DRB Application No.: 05DRB-01591 (P&F)
Project Name: M.R.G.C.D. MAP #39
Agent: Land Development Consultants LLC

Project # 1004479
Phone No.: 858-2441

RE: Tracts 133B1A1A, 133A2A1A, MRGCD Map # 39/pp & fp

**PLAT OF
LOTS A, B AND C
LANDS OF REGINA AVILA AND MARY LUCERO
WITHIN PROJECTED SECTION 13, TOWNSHIP 10 NORTH,
RANGE 2 EAST, NEW MEXICO PRINCIPAL MERIDIAN
TOWN OF ATRISCO GRANT
CITY OF ALBUQUERQUE, BERNALILLO COUNTY,
NEW MEXICO
OCTOBER, 2005**

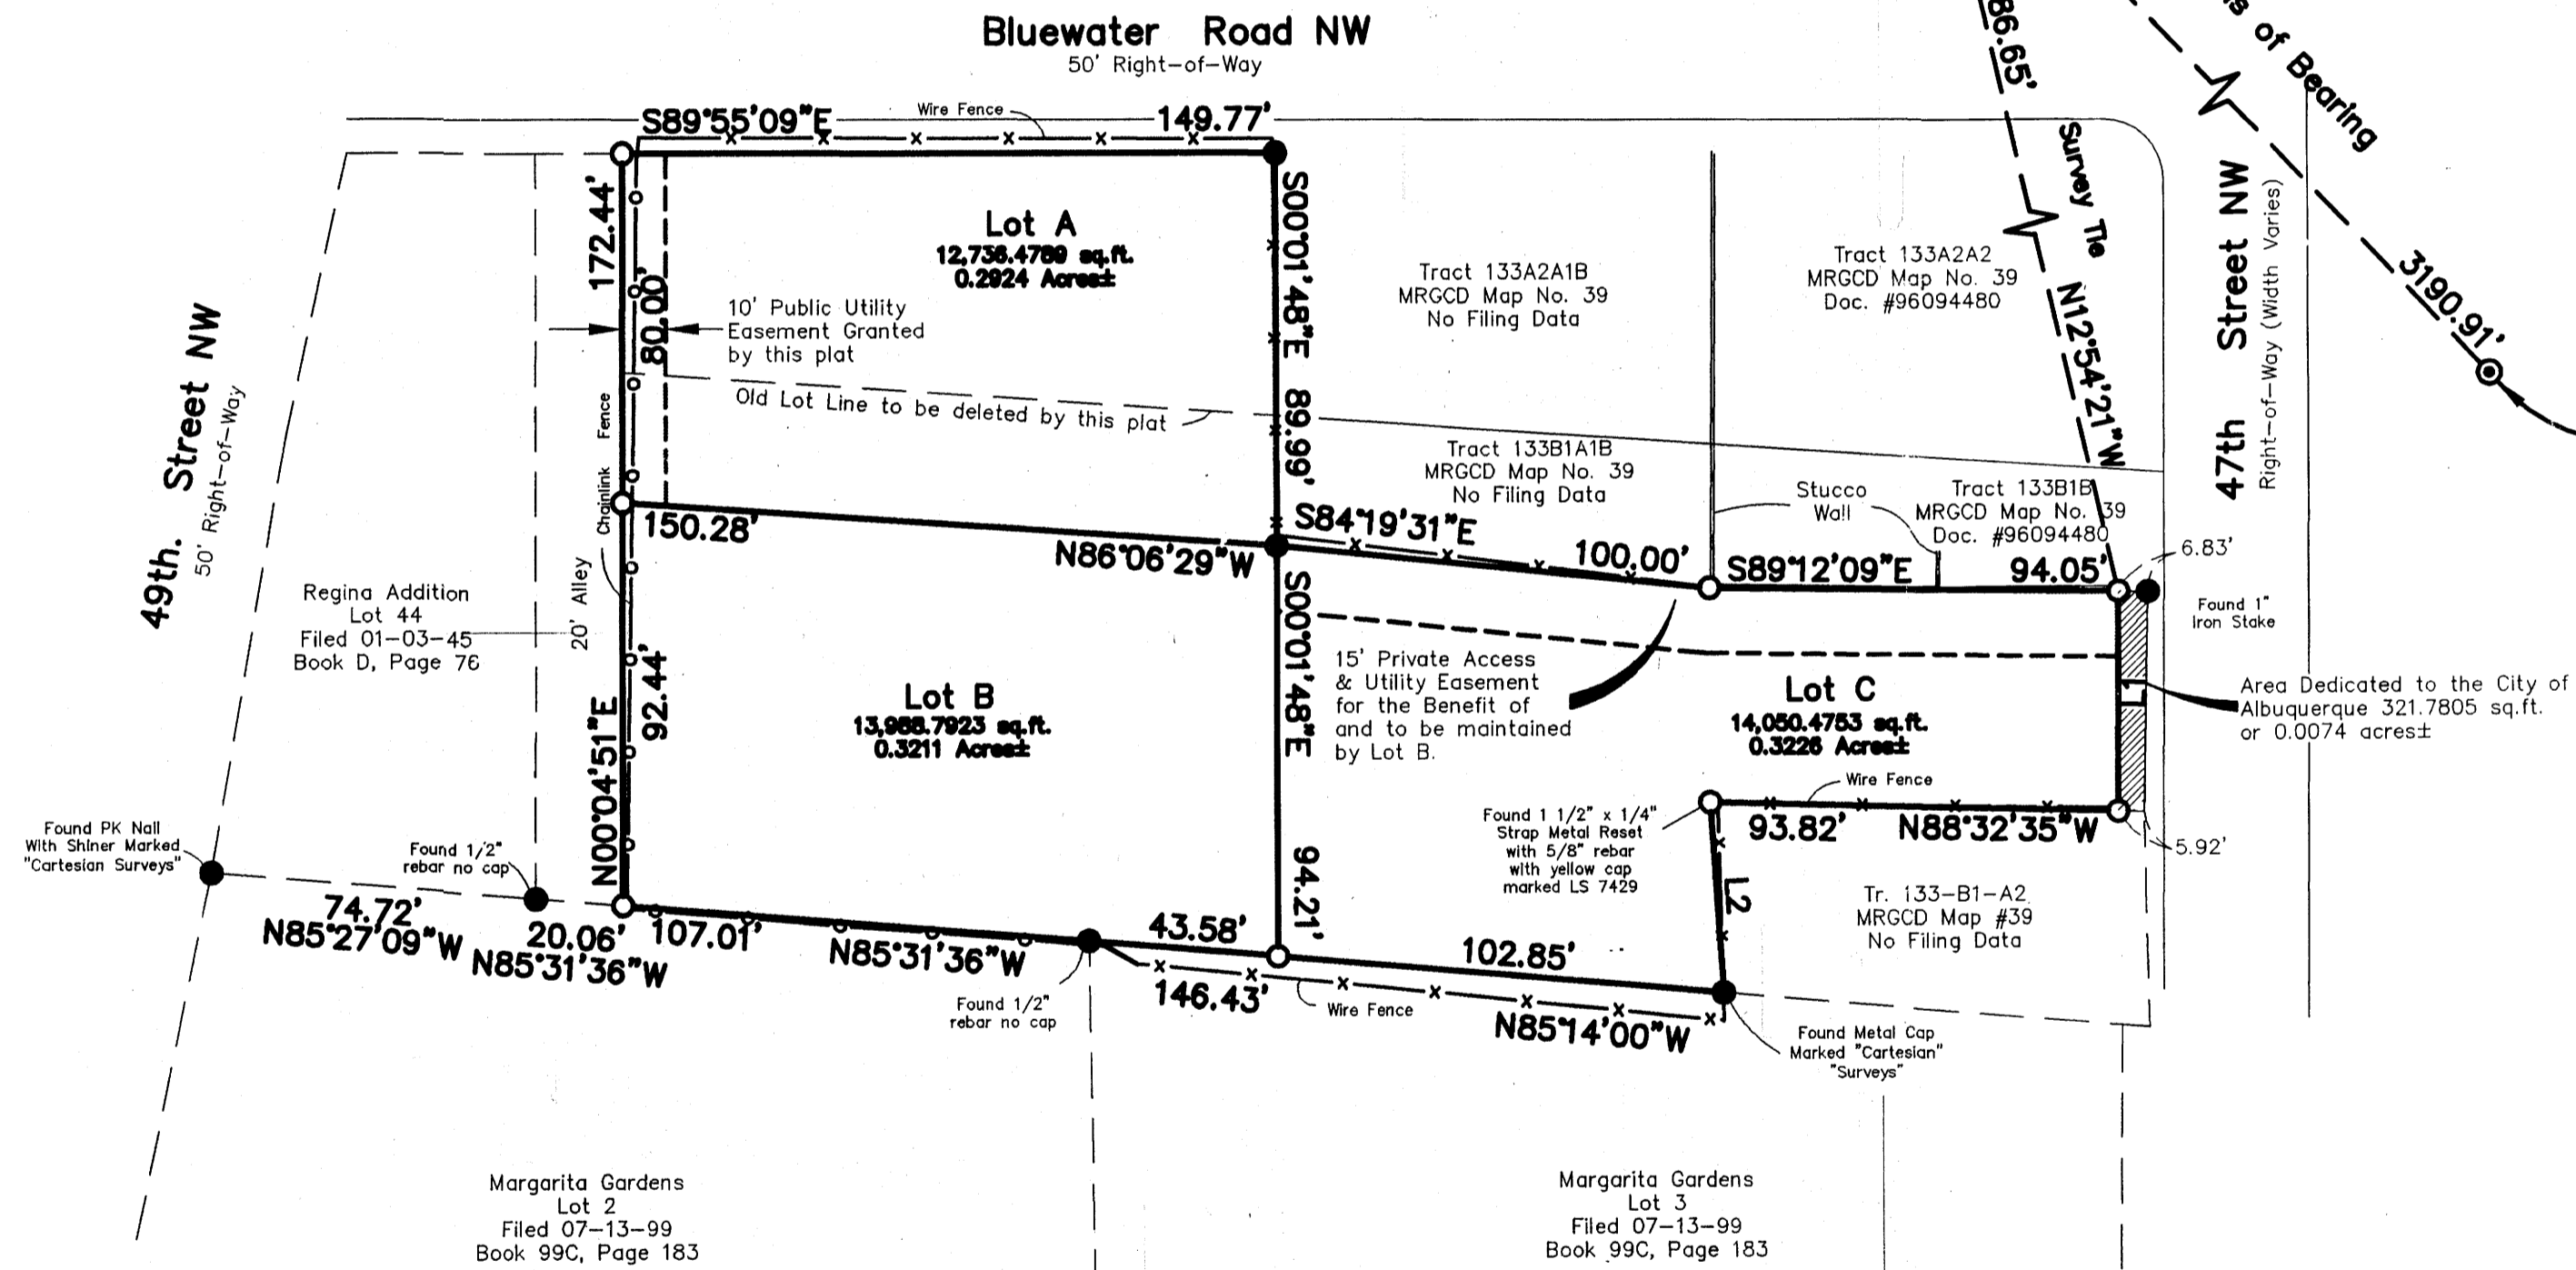
TRANSPORTATION: X CONSTN. of S.W. LOT A

X GAS LINE EASEMENT LOT A

Existing
 Site Plan

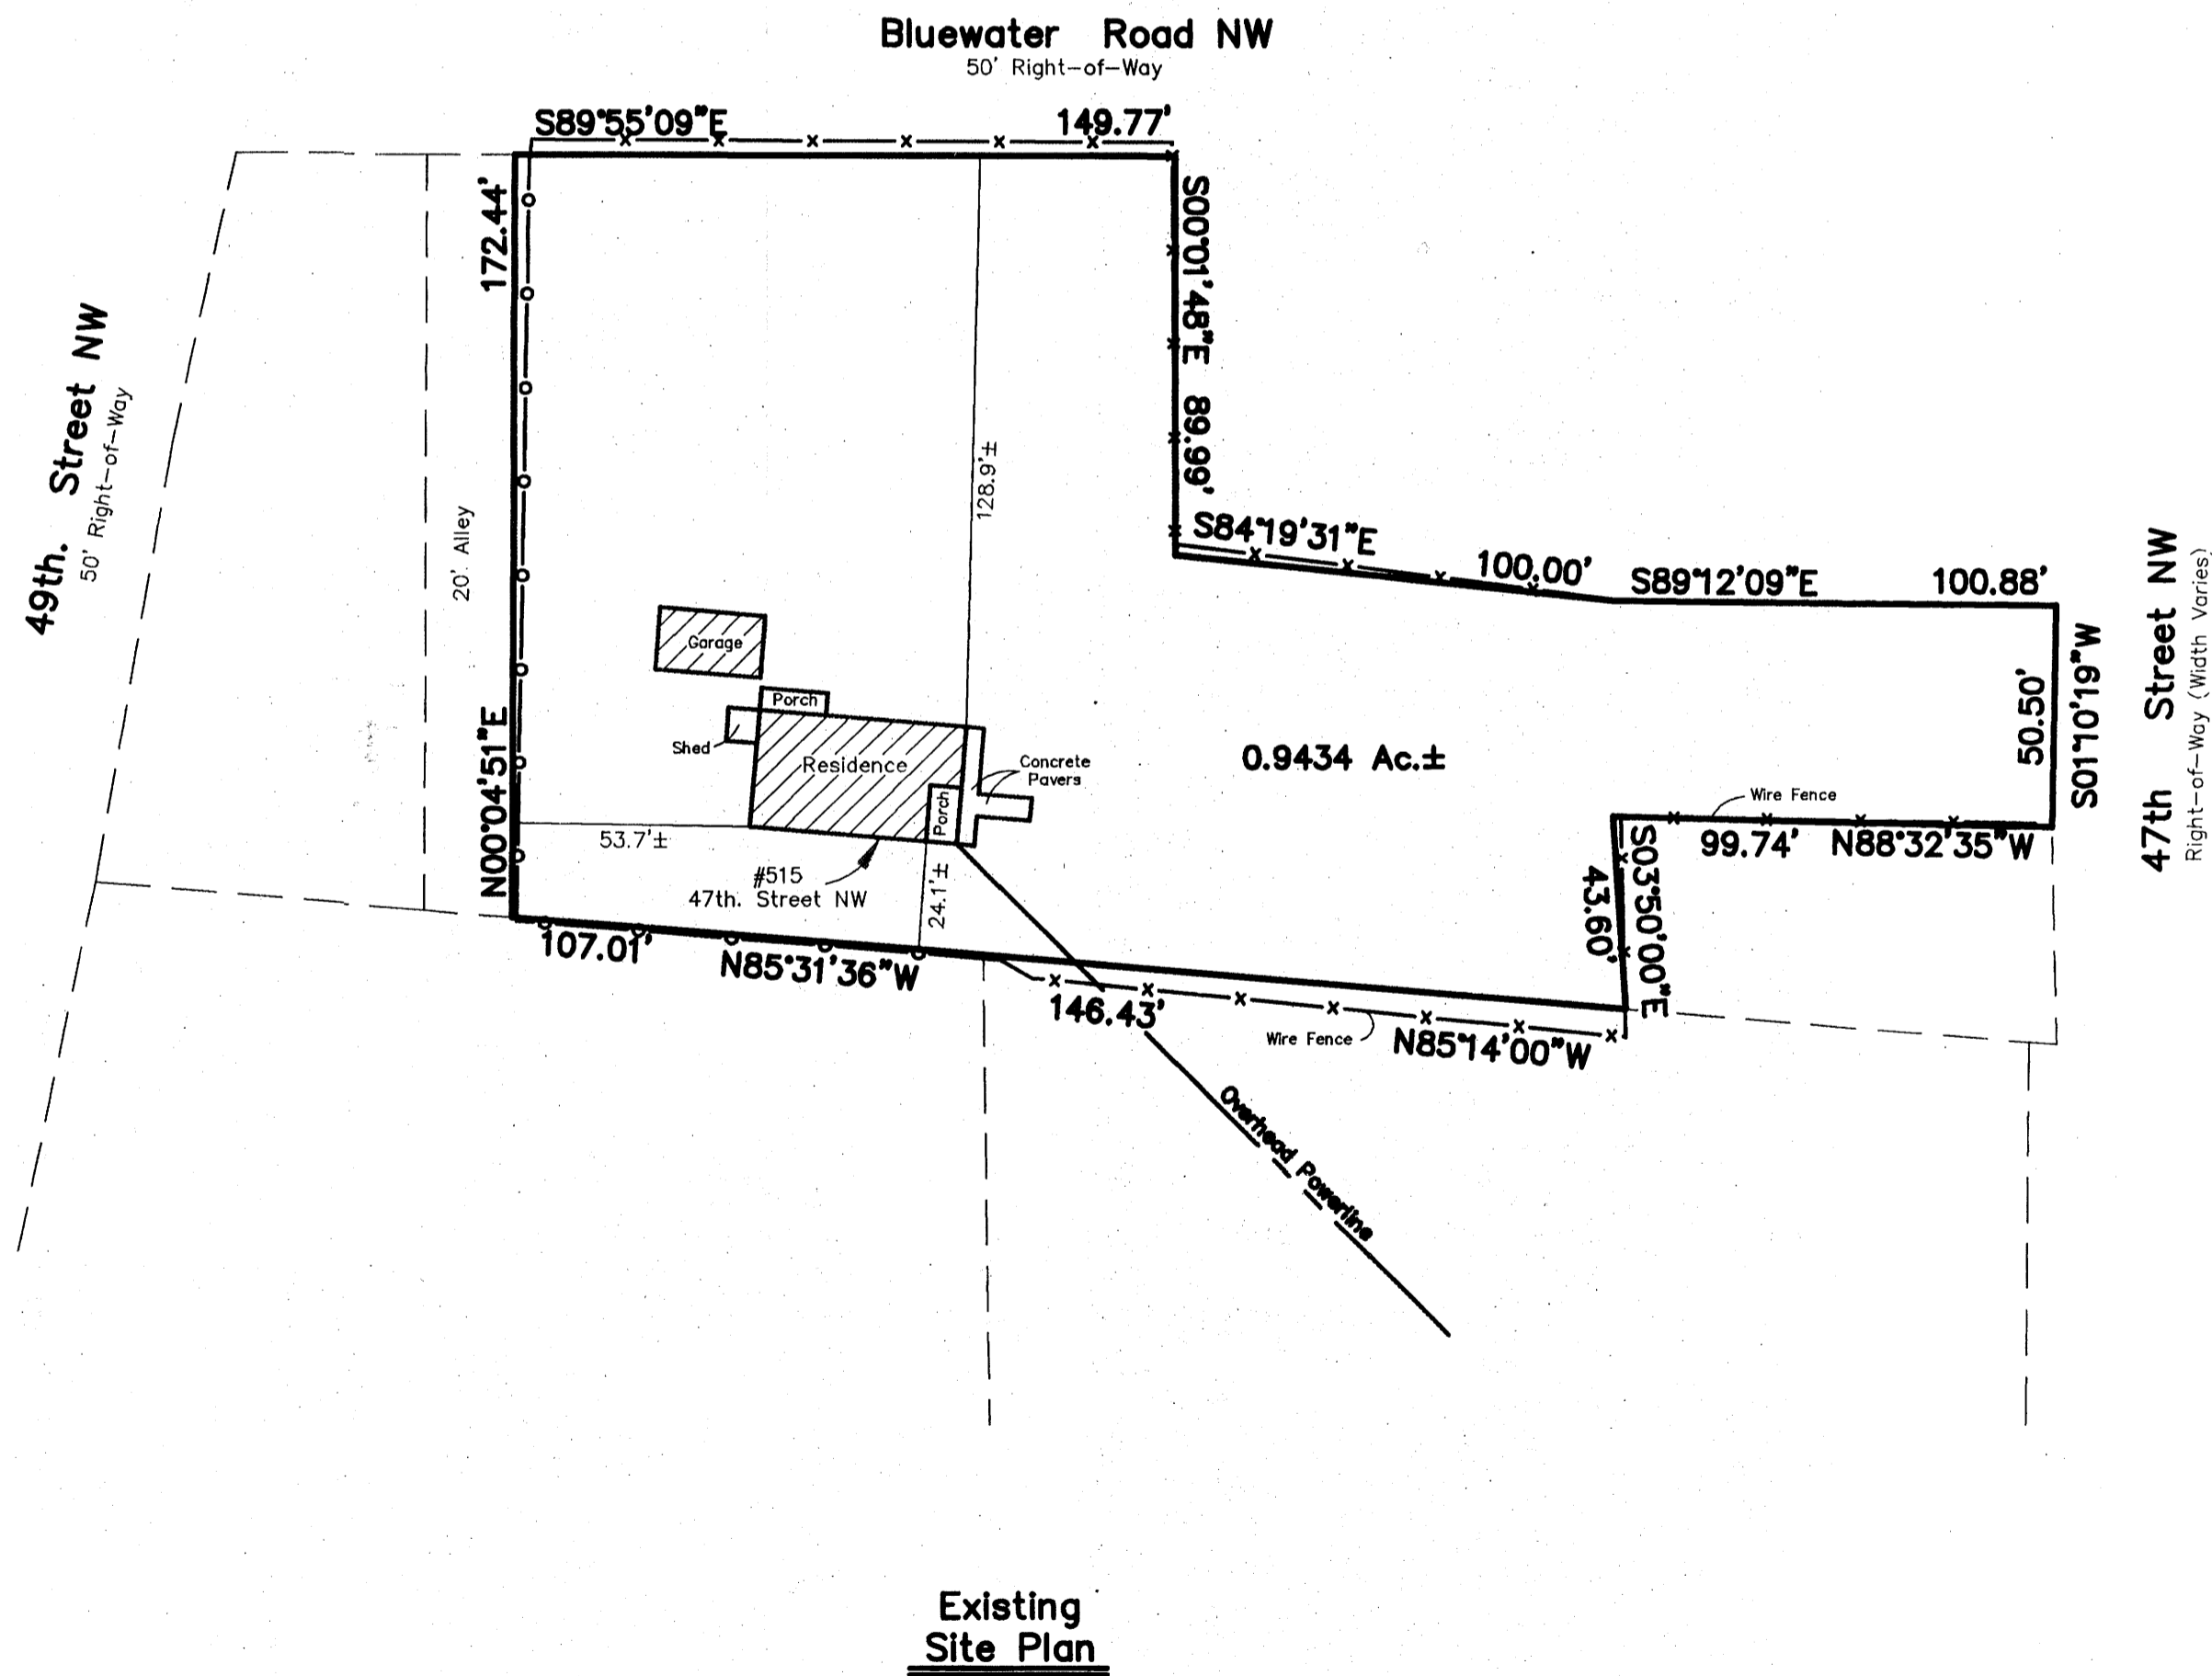
There is no objection to this request. Just make sure that, if the existing residence is going to remain, the new lot lines follow R-1 setback requirements.
